ZONING DOCUMENT

DISH WIRELESS PROJECT NUMBER
DN DEN00250B
 14 E CLOVER CIR. COLORADO SPRINGS, CO

SHEET TITLE
SITE PLAN

SHEET NUMBER
A-1

SHEET NUMBER
A-1

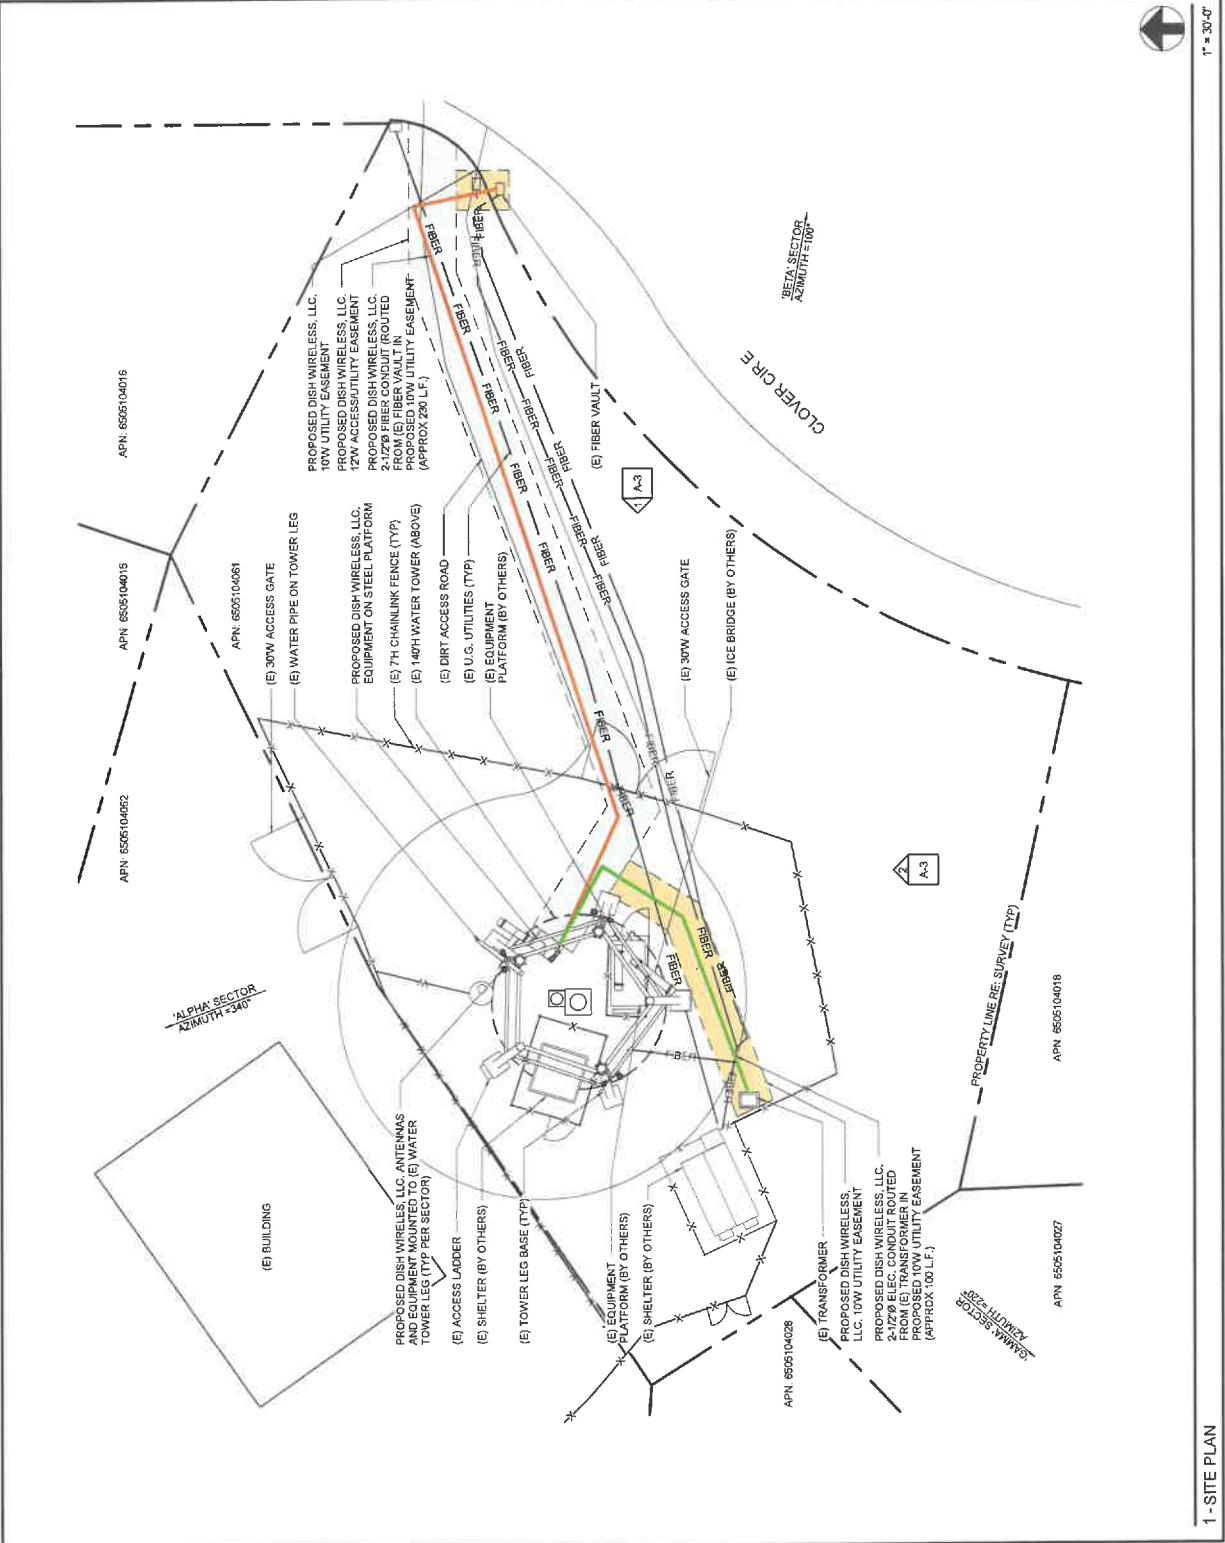
Please note per plat note six there is a 8' public utility and drainage easement on all rear, side, and front lot lines. Please show and label easement.

Please note the utility vault is outside of the property line. A Work in the Right-of-Way permit is required for the placement of utilities within the County's right-of-way. Please contact DPW to verify if a permit will be required.

please add the following to the site plan:
 -Owner name, contact telephone number, and email for responsible party
 -Applicant name (if not owner), contact telephone number, and email for responsible party
 -Property address
 -Property tax schedule number
 -Legal description
 -Lot size
 -Current zoning of the property
 -Location and dimension of the all property lines
 -The setback distances from the property lines

Please add "PCD File No. TWR-21-005".
